WELWYN HATFIELD COUNCIL
PLANNING CONTROL COMMITTEE - 15 MARCH 2007
REPORT OF THE CHIEF PLANNING AND ENVIRONMENTAL HEALTH OFFICER

N6/2007/54/FP & W6/2007/55/EM

ERECTION OF TWO STOREY REAR EXTENSION AT 70 BROCKSWOOD LANE,
WELWYN GARDEN CITY.

APPLICANT: MR & MRS L MARTIN

REAR ELEVATION

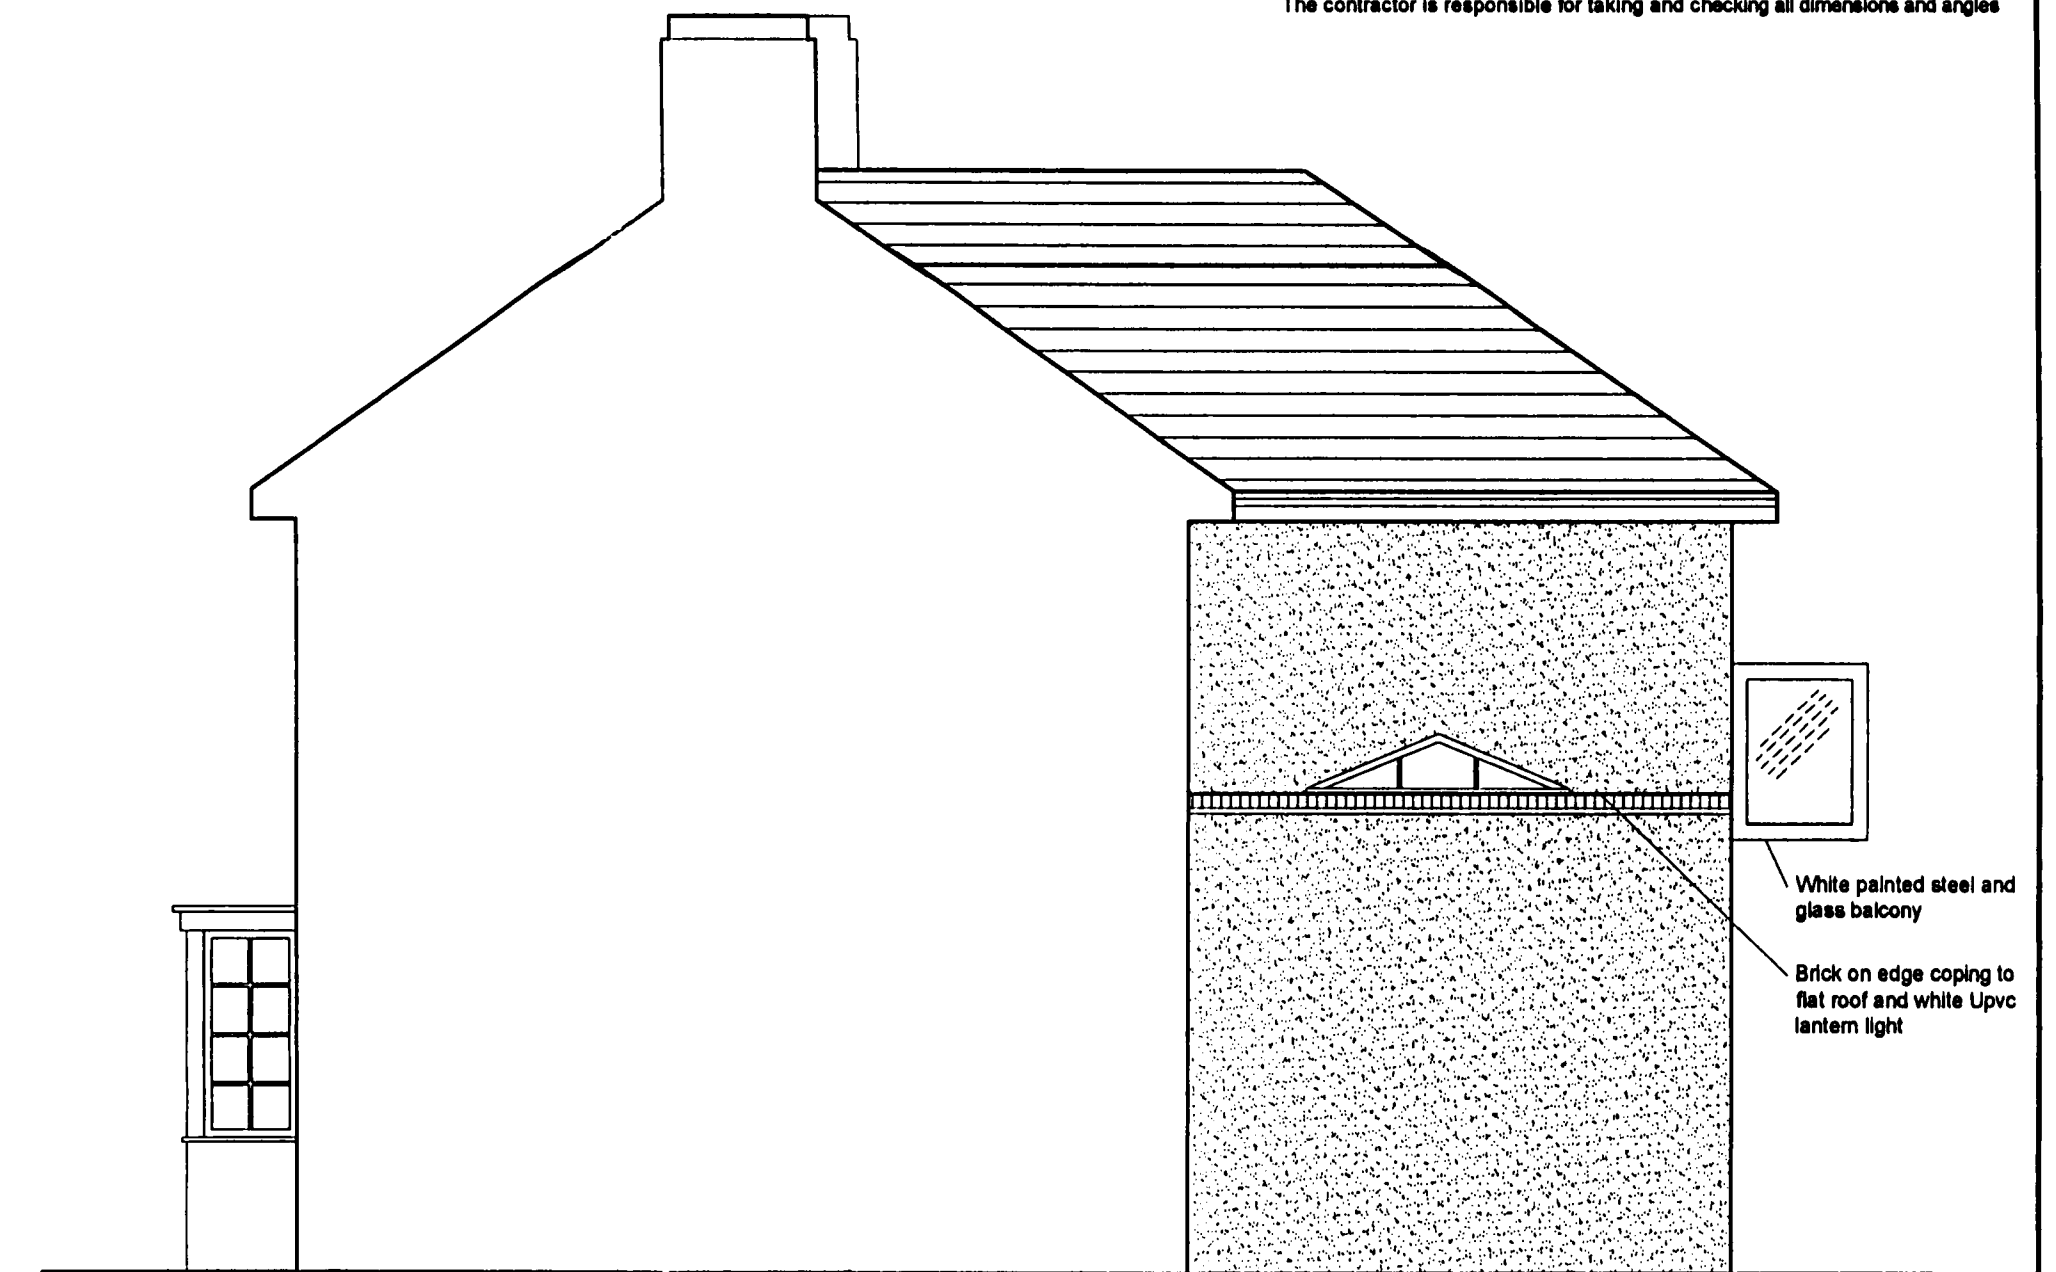
- 6.6 In terms of the design features there are a few alterations deemed to be required in order for this development to be acceptable. The applicant has to date proposed a glazed balcony from the French doors at first floor level. This feature is not considered to complement the existing character of the property and would not be acceptable within this Conservation Area. The applicant has agreed to remove this from the scheme entirely. The roof lantern above the enlarged lounge would protrude above the single storey extension by 350mm at the highest point. This would be an additional feature which could be considered to add to the character of the property. It would not appear out of keeping in the area given that the neighbouring property also has this feature on the single storey extension.

FIRST FLOOR

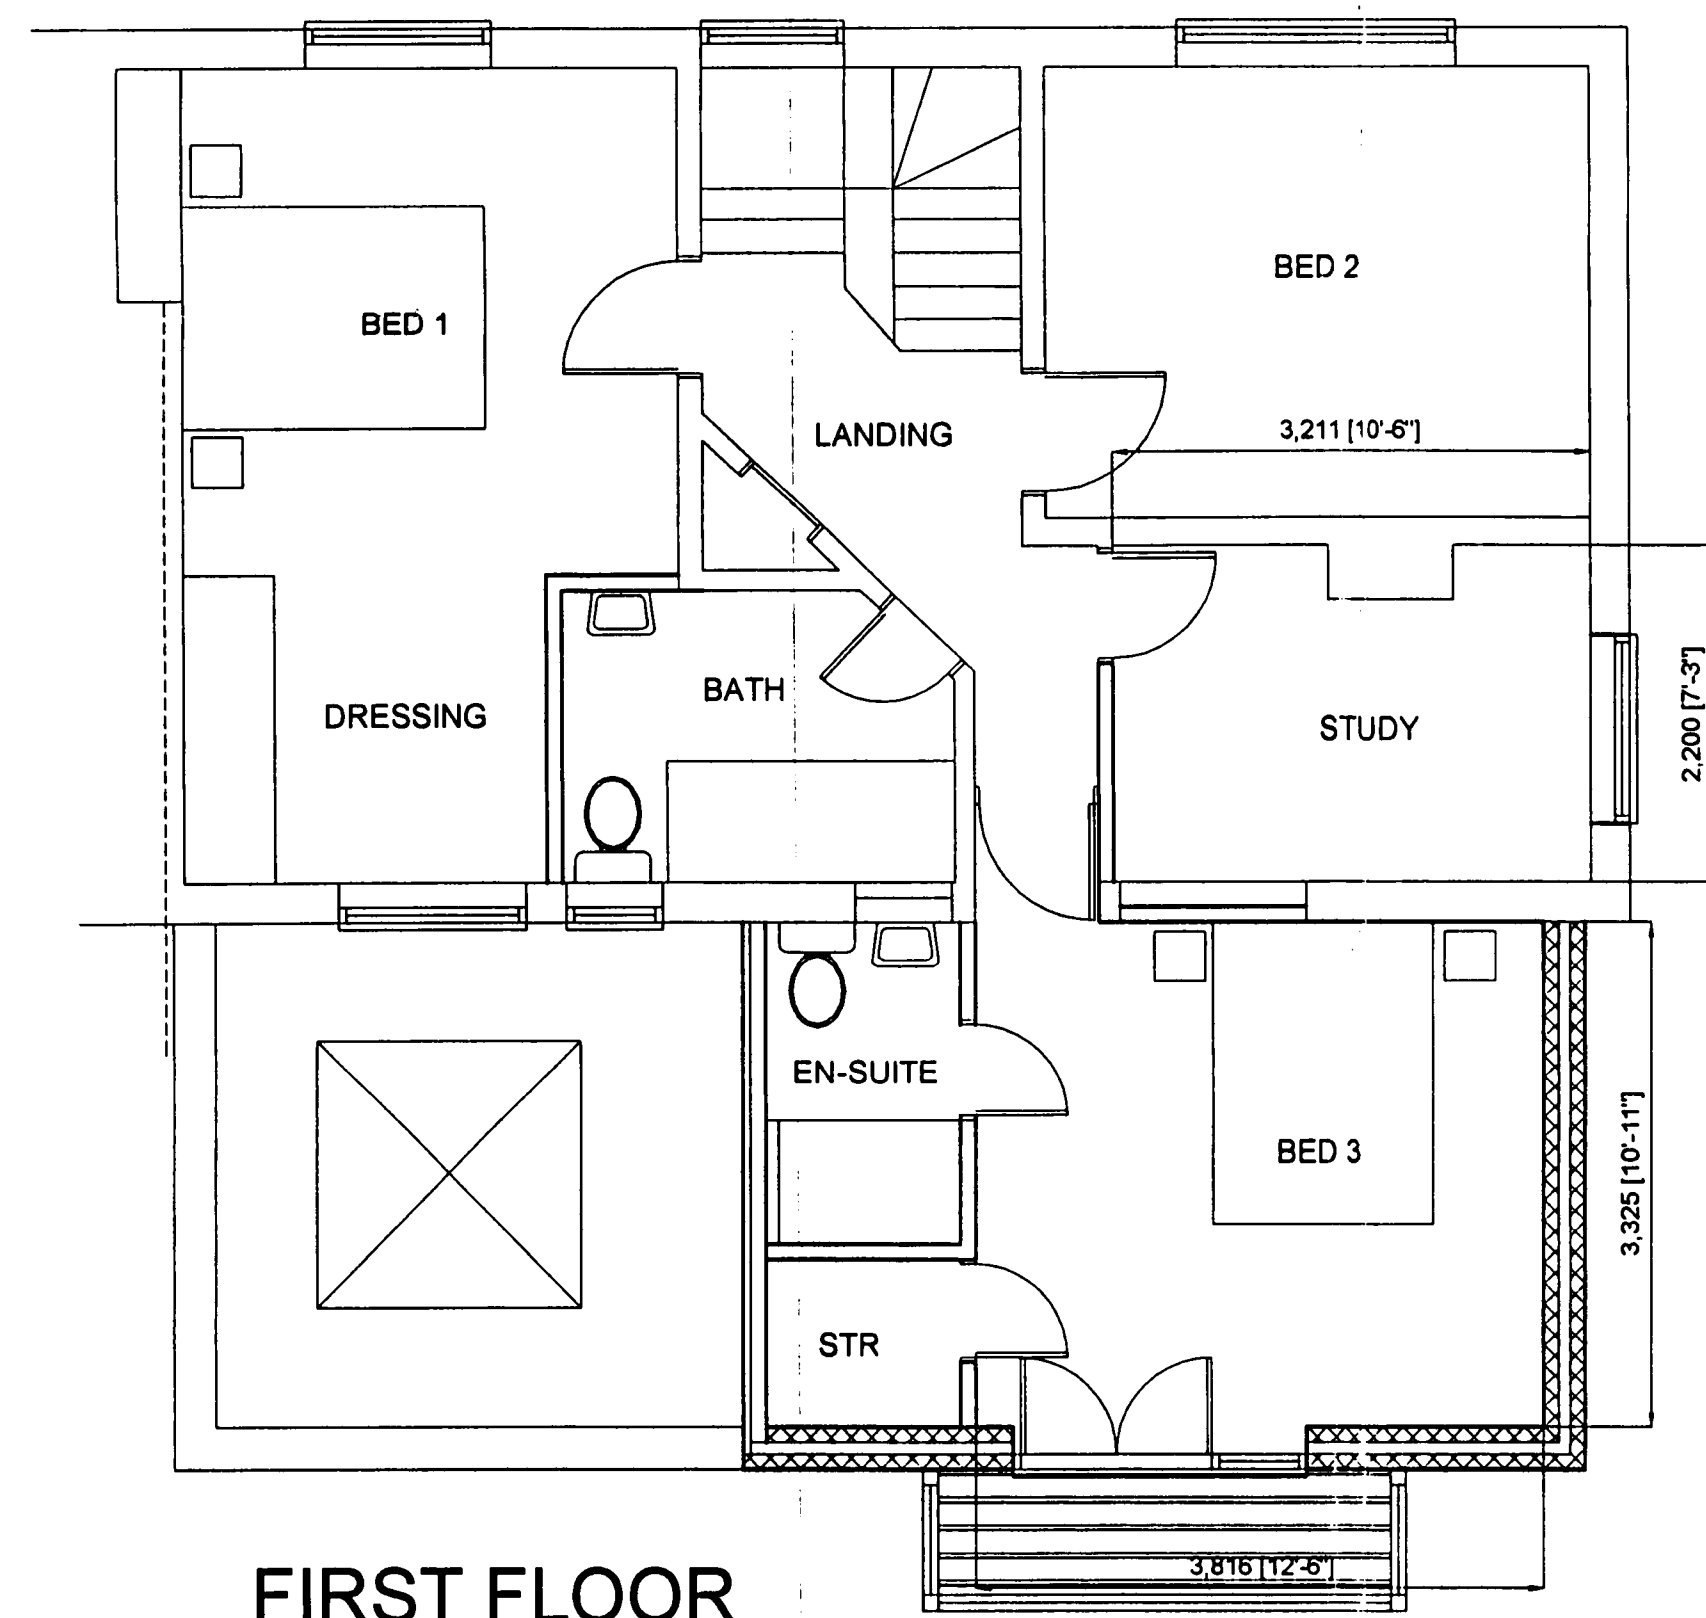
- Proposed first floor side window would look directly into an en-suite shower room and is too large;
- Balcony would overlook neighbouring rear garden and patio area in particular would result in loss of privacy and its design is not in keeping with the character of the property;
- Would prefer that the proposed glazed doors were windows which would be better aligned to the doors in the kitchen below;
- Effort has been made to keep the original character of the property and others around;
- Blocking of light from a Westerley direction;
- Concerns regarding exact position of wall and gutter along boundary, materials, height and maintenance;
- Issues relating to party wall agreement;
- Impact upon fence; &
- Out of keeping with other extensions in Brockswood Lane.

GROUND FLOOR

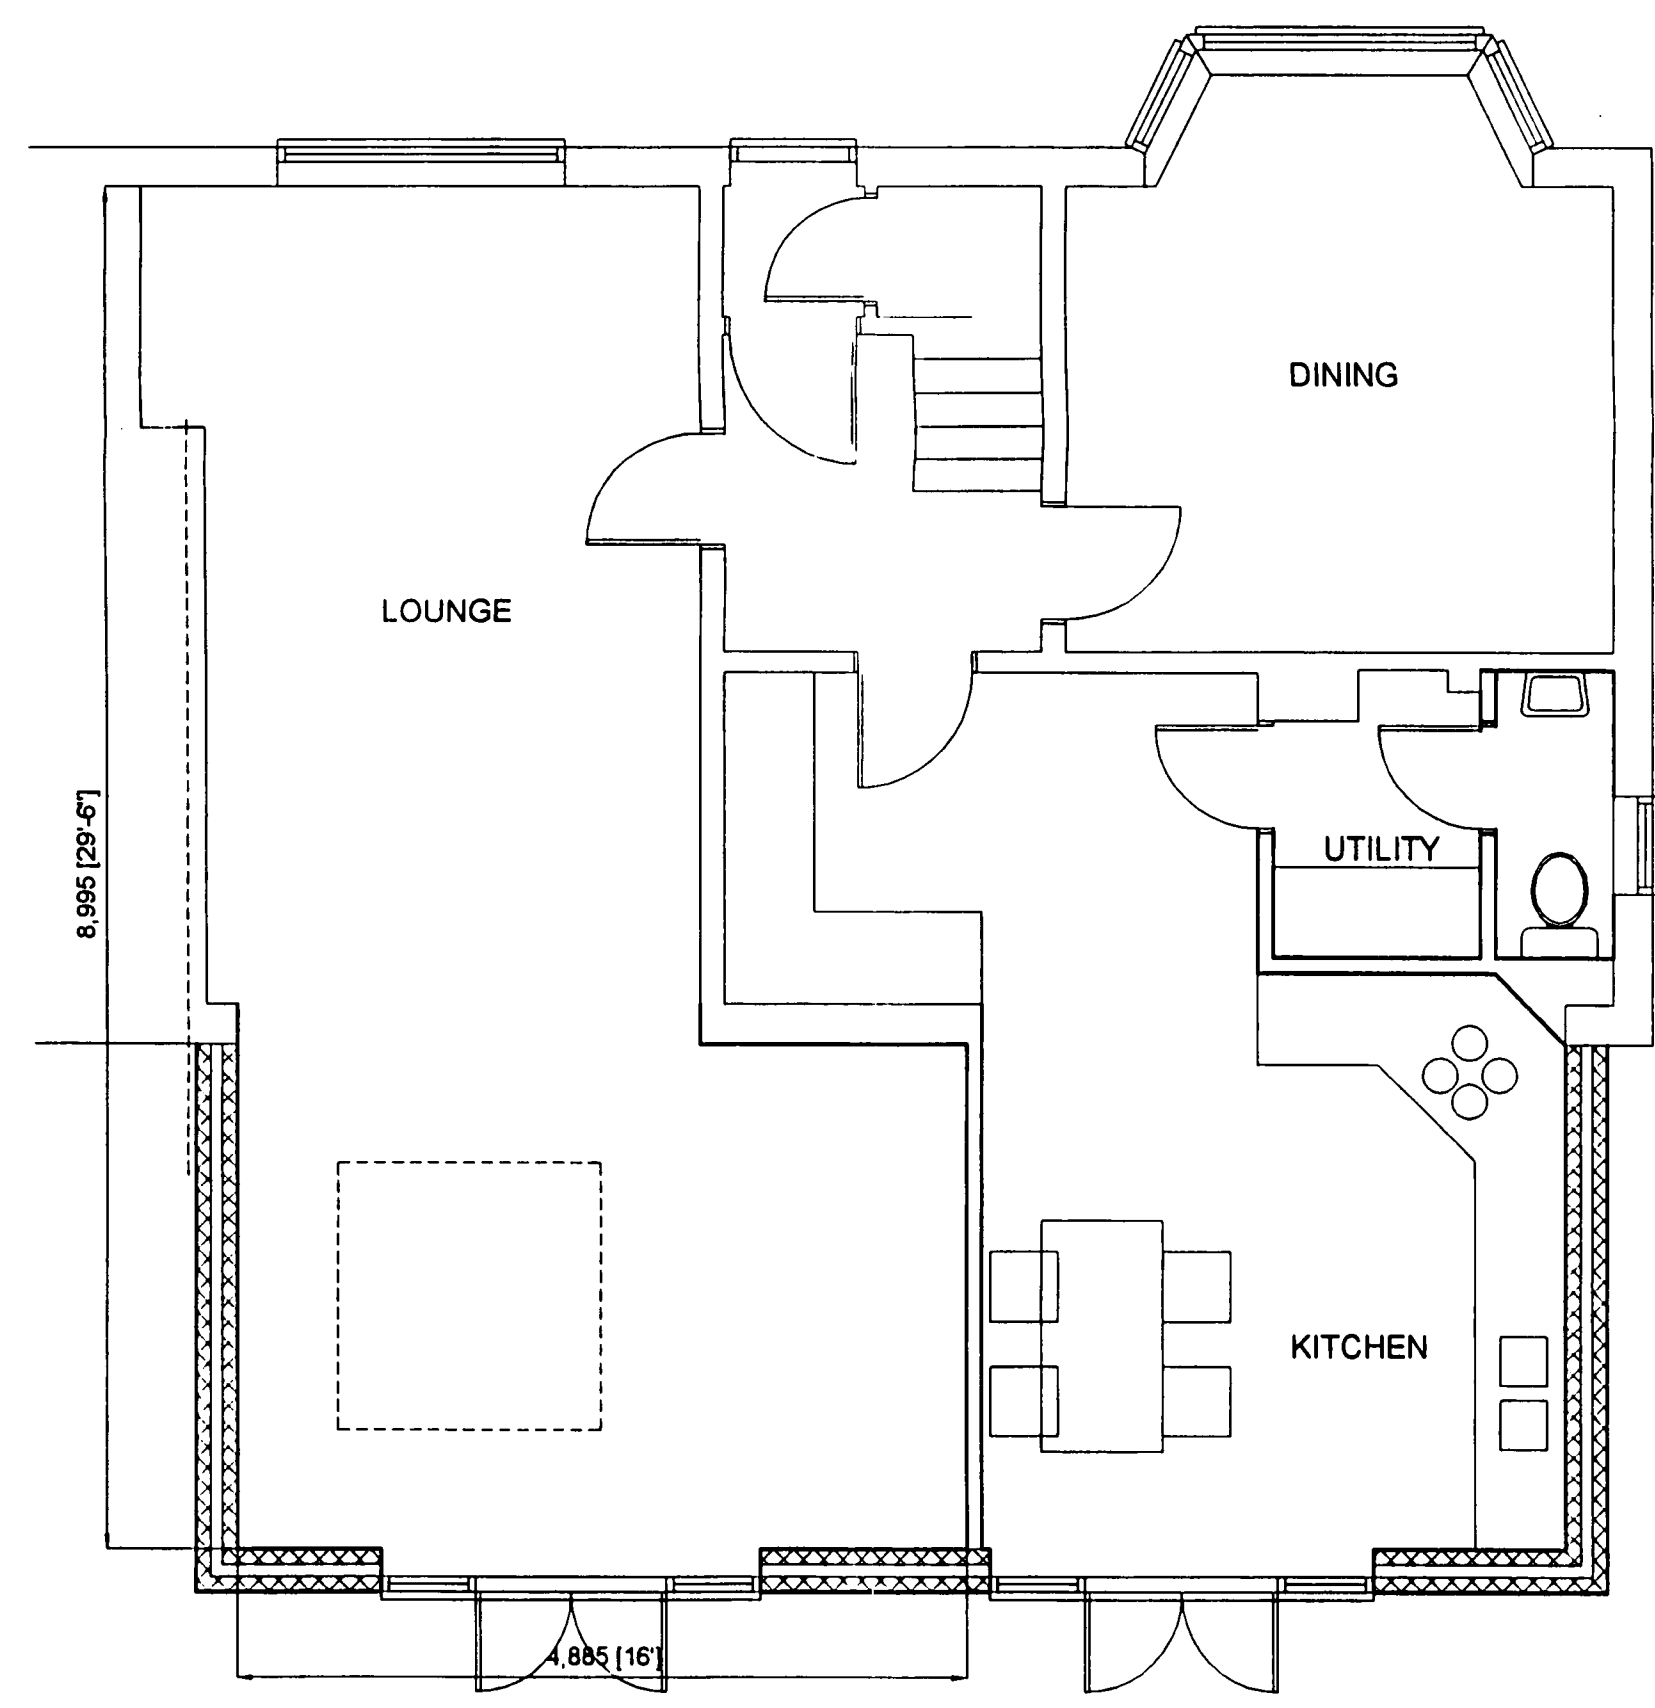
- 6.7 The single storey element would be constructed within 50mm of the property site boundary which is currently divided by means of a timber close boarded fence at this point. In terms of impact on the property boundary as existing it would be necessary to impose a condition should approval be granted to ensure that the

proposed extension does not affect the fence along the boundary line between the neighbouring properties.
